Subject: 1400024968- First Huddersfield, Old Fieldhouse Lane, Huddersfield, HD2 1AG
-2026/91401

Planning Application ref: 2026/91401
Northern Gas Networks Objection ref: 1400024968

Huddersfield – Hopton Top 300mm ST (1938)

Address: First Huddersfield, Old Fieldhouse Lane, Huddersfield, HD2 1AG
Proposal: Proposed electrification works including ground and gantry mounted chargers, overhead steel gantires and GRP feeder panels buildings

100% Parking Plan
Scale 1:500

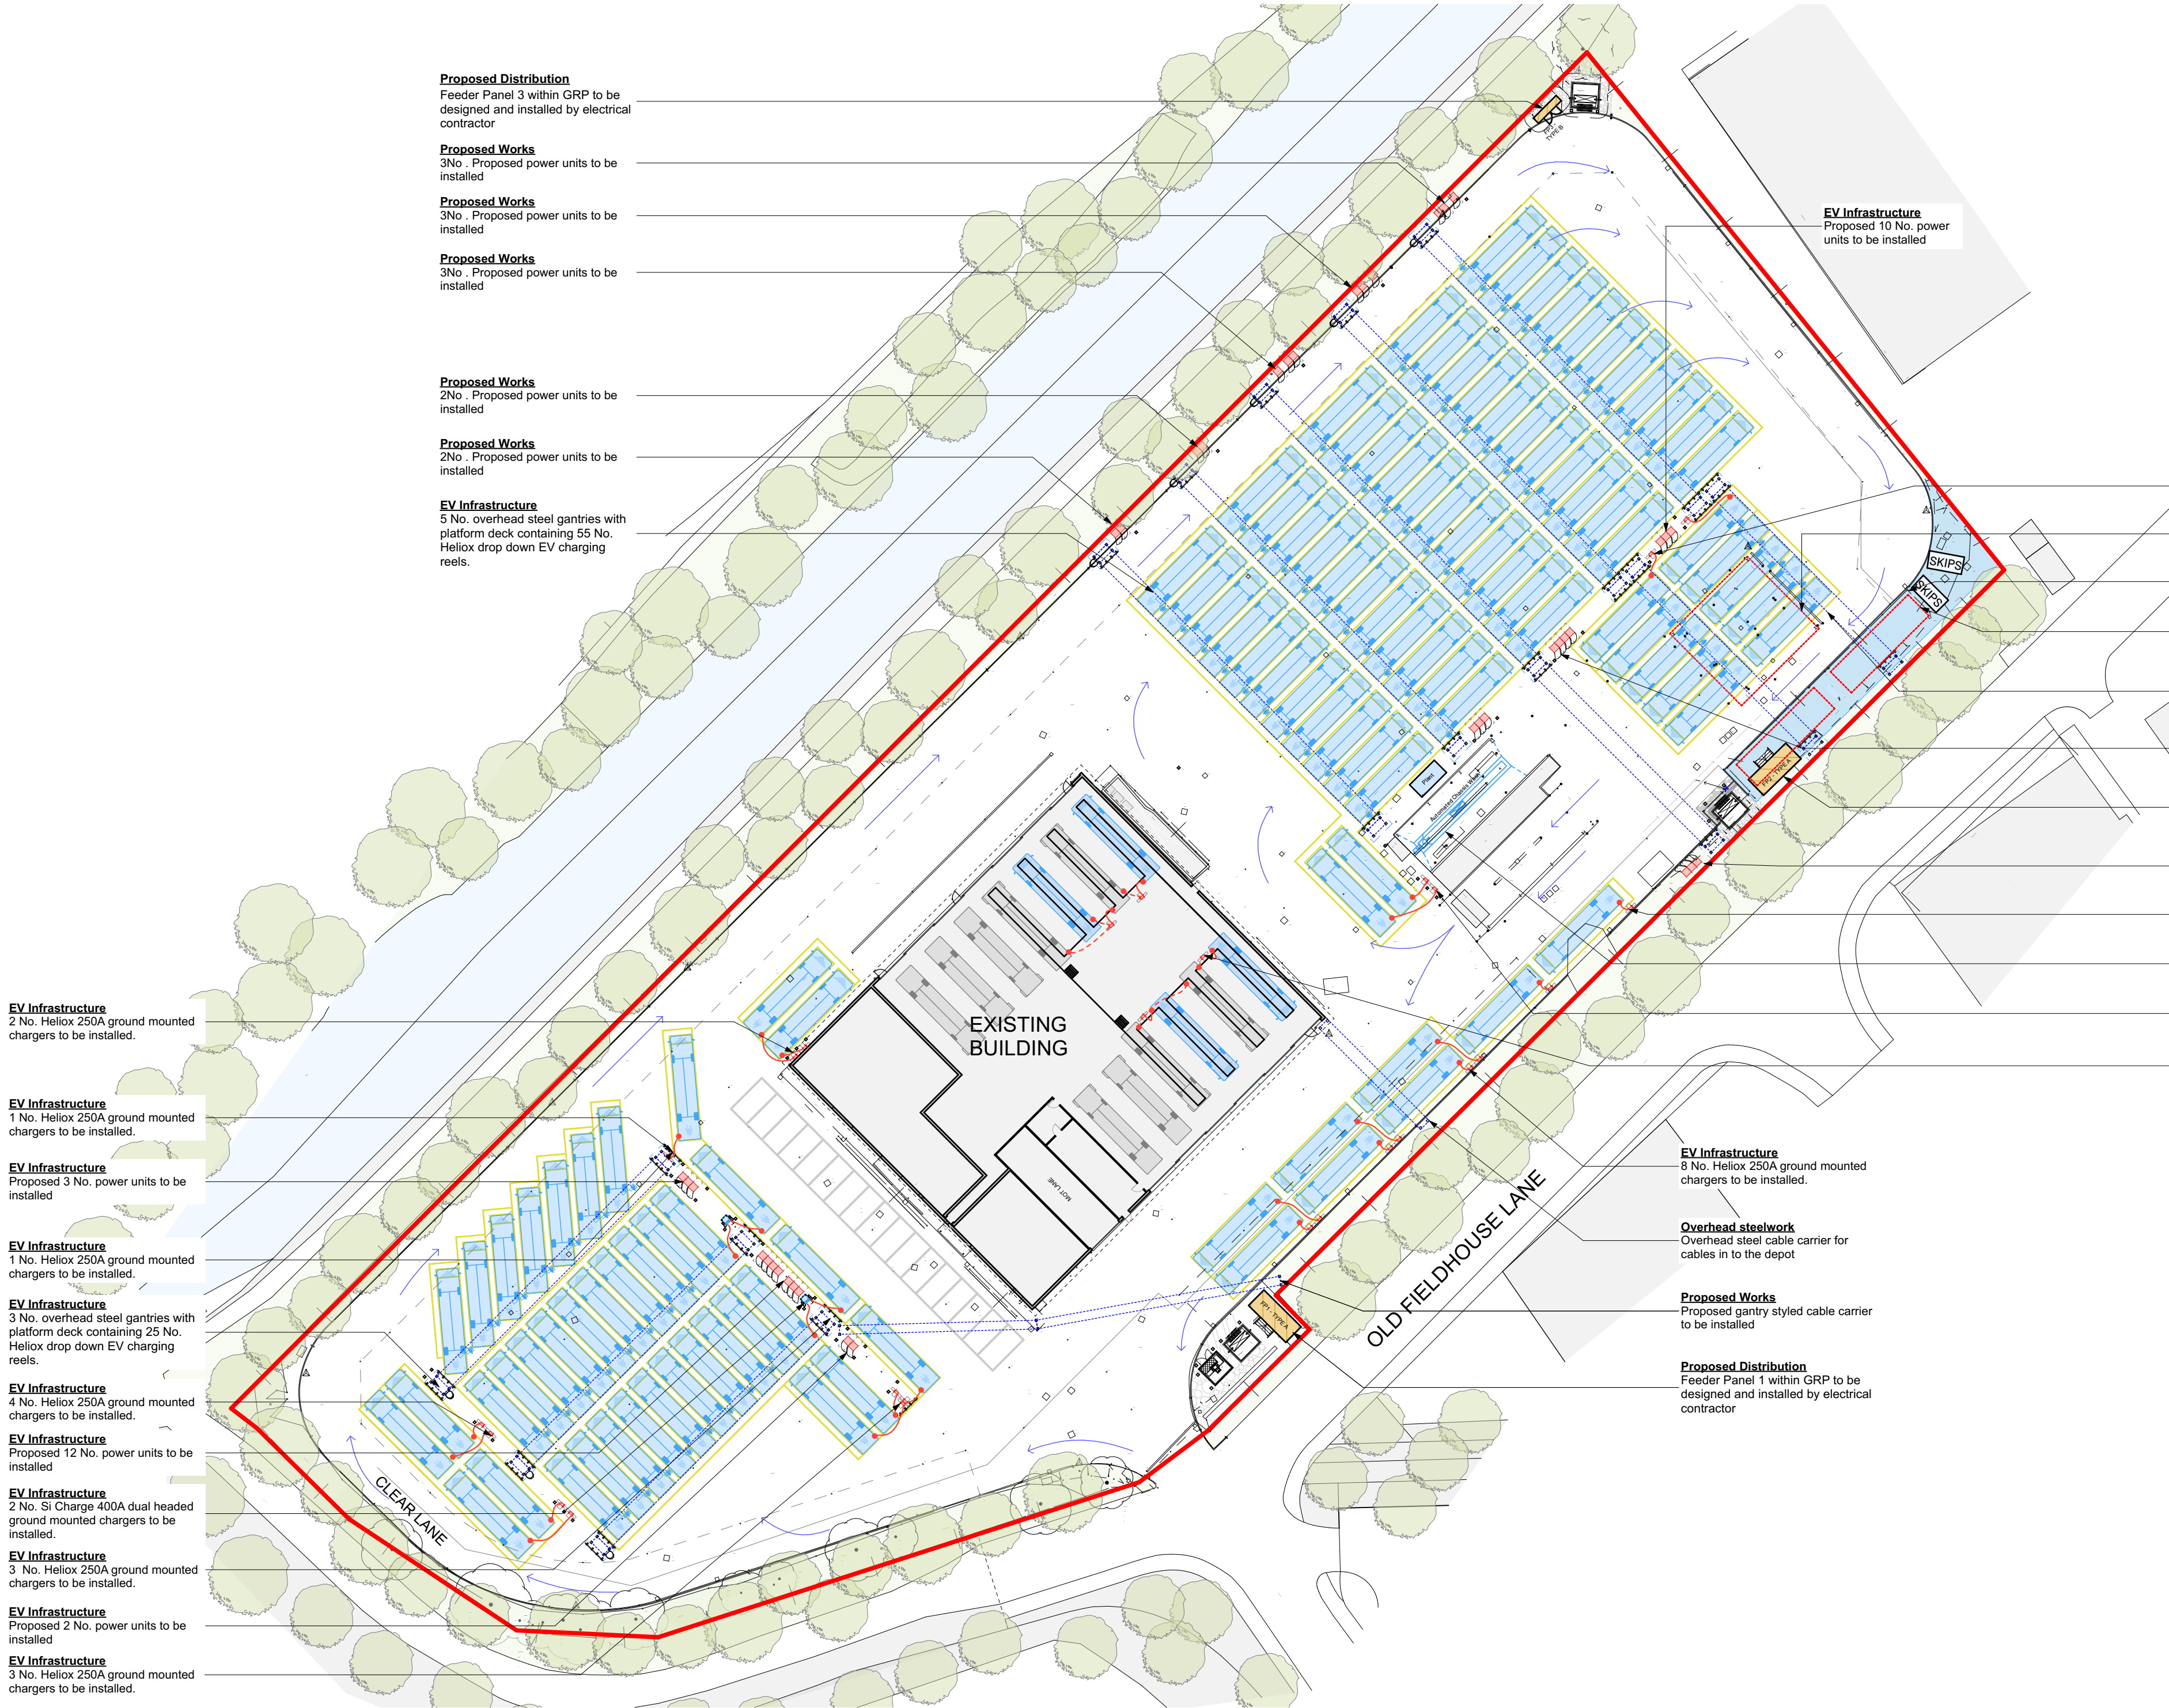
In general: **It is unacceptable for any building to be constructed directly over a High Pressure gas Transmission pipeline.**

I will arrange for the NGN objection to be withdrawn, if you can confirm that, (and assuming the above permission is granted), the ensuing works will not affect / or be close to our existing gas transmission pipeline as follows:

1. There will be no **NEW** occupied **buildings or extensions** within **14 metres** of the pipeline.
2. There will be no **groundworks** within 10 metres of the pipeline.
3. There will be no new trees planted within 10 metres of the pipeline.
4. There will be no **new permanent** or **temporary vehicular** crossing points over the pipeline.
5. There will be no new services (water / electric / comms / gas etc), placed in the vicinity of, or crossing the pipe at any point.
6. There will be no explosive blasting within 250 metres of the pipeline.
7. There will be no ground vibrations associated to piling, within 15 metres of the pipeline.
8. There will be no new balancing ponds or drainage within 7 metres of the pipeline

We would like assurances that any electrical equipment installed will not adversely interact with our pipeline or its cathodic protection, this may require interference assessments completed by yourselves (this assurance may include electrical testing procedures).
